Immingham Eastern Ro-Ro Terminal

Document
IOT Operators, Letter to ABP, RE: further enquiries including design parameters, vessel impact protection and SOCG - Attachment 1: Beckett Rankine, Memo, Design Basis Review - Attachment 2: IOT Operators draft SOCG

CLIENT	NASH Maritime					
PROJECT TITLE	Immingham Ro-Ro Terminal Impact Protection					
SUBJECT	Impact Protection					
DOCUMENT TITLE	Design Basis Review					
DOCUMENT REF	2333-BRL-01-XX-MM-C-0001					
REVISION RECORD						
REV	STATUS	DATE	SUMMARY OF CHANGES	PREP	CHK	APP
P01	S2 – For Information	27/11/2023	-	GT	TKHB	TKHB

1 REVIEW OF IERRT IMPACT ASSESSMENT DESIGN BASIS DOCUMENT

Figure 1-1. Vessel Impact Protection Structures

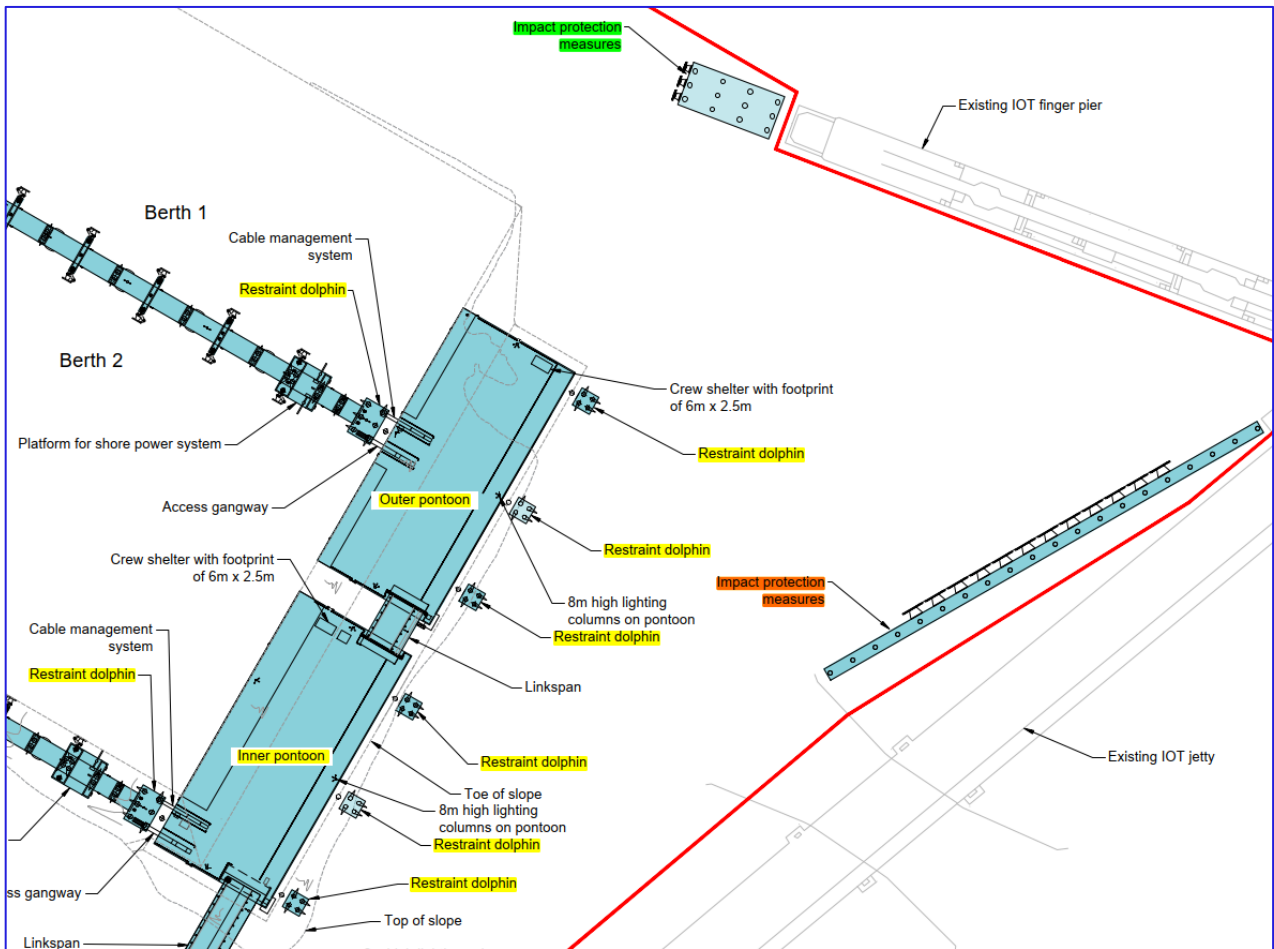
- 1.2.1 The future vessel impact velocity is 1.8knots, as opposed to 2.5knots for all other vessels. It's not clear how this has been determined and there is no justification within the document as to why the velocity is reduced for the future vessels.
- 1.2.2 There is no explanation of the possible modes of impact with the IOT structures and/or the protection structures. Likely impact scenarios should be set out so that the designer of the protection structures understands the possible angles of approach of the impacting vessel.
- 1.2.3 It is unclear how the 5m offset of the protection measures to the IOT structures has been assessed to be a safe offset distance. The document contains no assessment of whether 5m clearance is sufficient to prevent contact with the IOT

structures taking account vessel overhangs and deflection of the impact protection structure under load.

1.2.4 The design basis document doesn't clarify what impact the IERRT pontoons and associated restraint dolphins are designed for, and if these are designed to fail upon impact or will remain serviceable. There is a reference to a performance specification (doc ref: 4021009-JAC_ZZ-01-SP-C-00017) but this document has not been made available to the IOT team for review.

1.2.5 To note, the design basis states that there is no lighting to be provided on the protection structures. This should be reviewed for safety navigational reasons by the IOT team.

1.2.6 Also, to note, there is no allowance for access between IOT structures and the impact structures.

1.3.1 The design impact force is not provided.

1.3.2 There is no information about the assumed ground conditions.

1.3.3 There is no information about the pile sizes or whether raking piles are proposed (which could extend below the IOT jetty).

1.3.4 There is no information about the fenders proposed.

1.3.5 There is no information what corrosion protection system is assumed.

1.3.6 There is no information on any maintenance requirements of the impact assessment structures.

1.3.7 There is no information on whether the impact protection structures are designed to withstand environmental loads, and if so, what these are.

1.3.8 No design calculations have been provided within the design basis to justify the size of the impact structures, the degree of deflection under impact and whether the proposed general arrangement is viable. These details should be provided to allow IOT team to better understand the suitability and mechanism of the impact protection system to protect the IOT infrastructure.
